Regarding <https://www.kirklees.gov.uk/beta/planning-applications/search-for-planning-applications/detail.aspx?id=2021%2f93621>

1. Access and Transport links - Health and Safety
2. Suitability of the submitted plans
3. Queries on the Planning Application
4. Impact on existing properties
5. Conservation Area
6. General Observations

Description: PROPOSED SITE PLAN & 3D VIEW

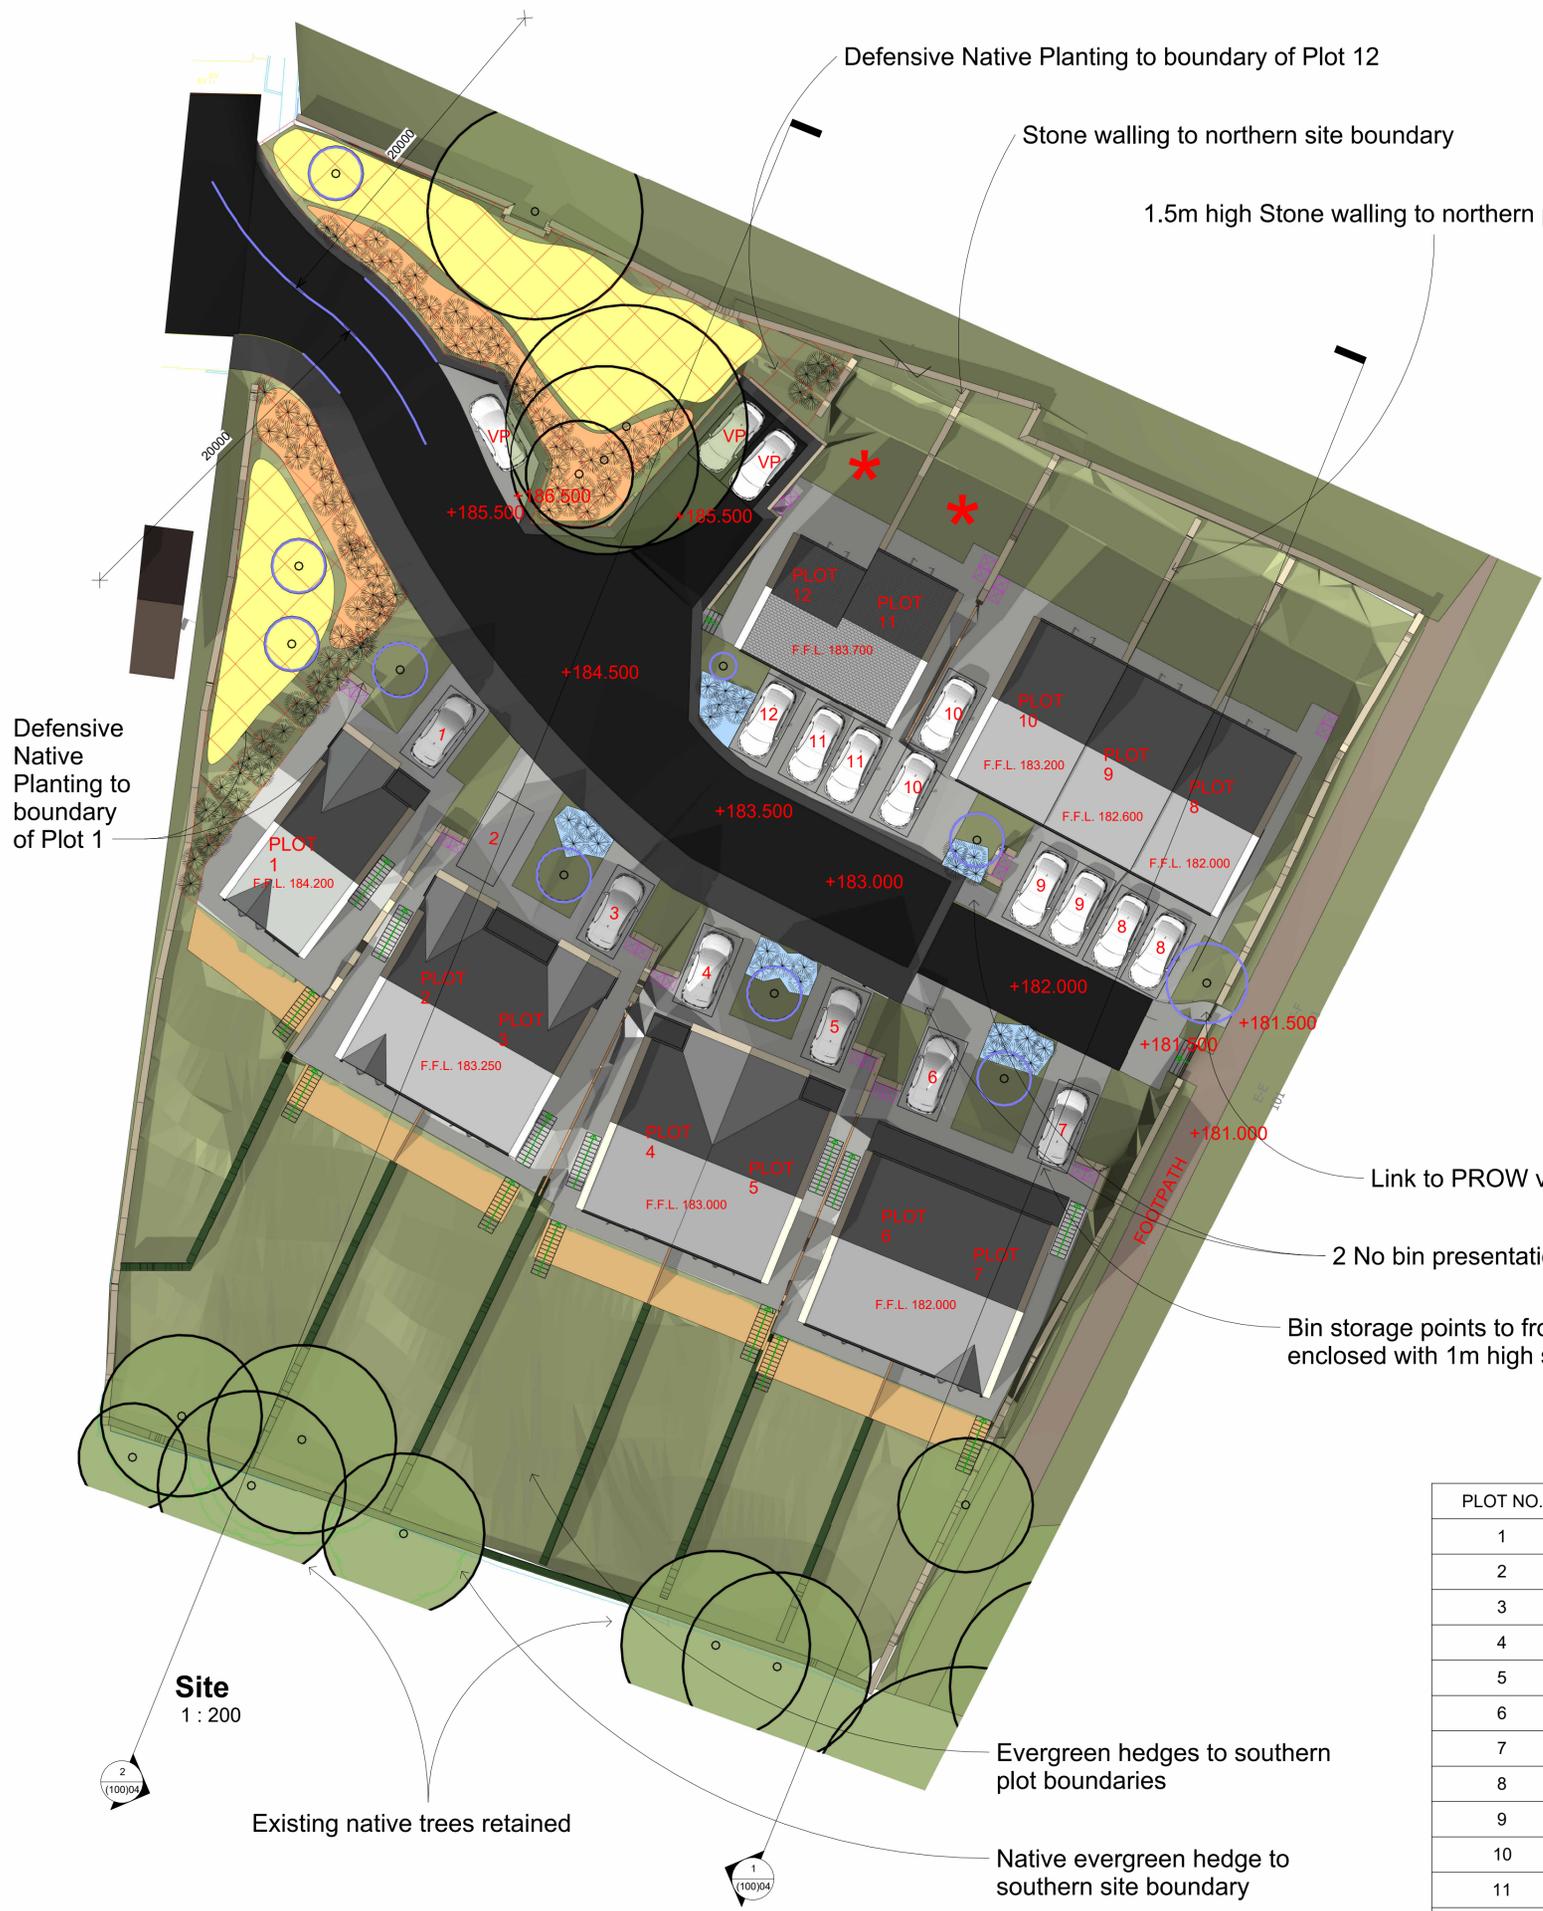
This is one of our biggest concerns. Already the roads around the proposed site are narrow and well used. It is not to say they are congested with continual queuing traffic but they are certainly well used for their size and width, in particular *Small Lane* and *Claywell* which are small, tight narrow roads. Putting more traffic on these roads is likely to increase the risks to current users, pedestrians and cyclists which seems to go against the Active Travel Plan and will increase the chance of further major accidents and possibly fatalities. Considering this is heavily used by children going to and from school it would seem to be an unnecessary risk to impose on the neighbourhood.

And what the COVID pandemic has taught us is that there is an increasing shift towards online shopping and hence vehicles larger than family cars are being used to deliver products to homes. With this in mind the current proposed access to the development through Fulwood Drive would only exacerbate the current growing problem that we highlighted originally; *(Then with increased number of houses there will be an increased number of internet based shopping which leads to an increased number of delivery vehicles, on top of those purchases that require home delivery. This would place an unprecedented demand on the narrow roads of the area. And with Satellite Navigation systems consistently bringing traffic for Drakes Mill and Fulwood Drive down Claywell and seeing vehicles stuck and having to reverse to then try and get down Carr Top Lane and getting stuck and then having to go back up Carr Top Lane and attempting impossible right turns on the very sharp bend, you can begin to see a picture of increased confusion and congestion of large vehicles on small roads. And this problem is only set to get worse by the increasing uptake of Satellite Navigation for delivery drivers. This is again a massive concern of the Health and Safety of local residents.)*

On the current plans there are less trees being retained and the main central tree that on the report that was classed as Category B, tree T25, now appears to be part of the area that is to be built on.

The new application incorporates up to 4 storey buildings on very substantial footings (Plots 6 - 10) which all contributes to having a severe impact on the current housing and a much greater loss of privacy.

It is also not specified if these buildings will be “no less than 21 metres is recommended between facing windows of habitable rooms” https://kirklees-consult.objective.co.uk/portal/pp/spds/house_extensions/house_extension_spd?pointId=s1598446798441 because it is our belief from rough measurements that the proposed buildings will be significantly closer than 21 metres to our current kitchen.

But even if they were further than 21m (which we strongly doubt) it will still be a huge impact and loss of privacy to have such large buildings overlooking existing properties because the plans are now “face to face” whereas before they weren't the proposals were for the new properties to be “side-on” hence mitigating the impact.

So if the houses could be reverted to the direction on the original plan (left image) and if Plots 9 & 10 could be located below Plots 7 & 8 then there would be no impact to the existing houses and no objections because they would be lower down the hill and not have an effect or be able to see into currently habitable rooms. Because as you can see from the right image which is the current application there is a significant impact on the current Listed Building sited within a Conservation Area.

- **Parking**
Visitor parking looks woefully inadequate meaning people will park outside houses or on Fulwood or around Small Lane etc
- **Biodiversity**
The outdated version of the bio diversity report refers to eight properties but now there are 10 so the impact will be even higher than the quoted -40.58% yet they are quoting -38.07%
And as Japanese Knotweed has been identified on the land how do we know this development will not increase the spread to local properties?
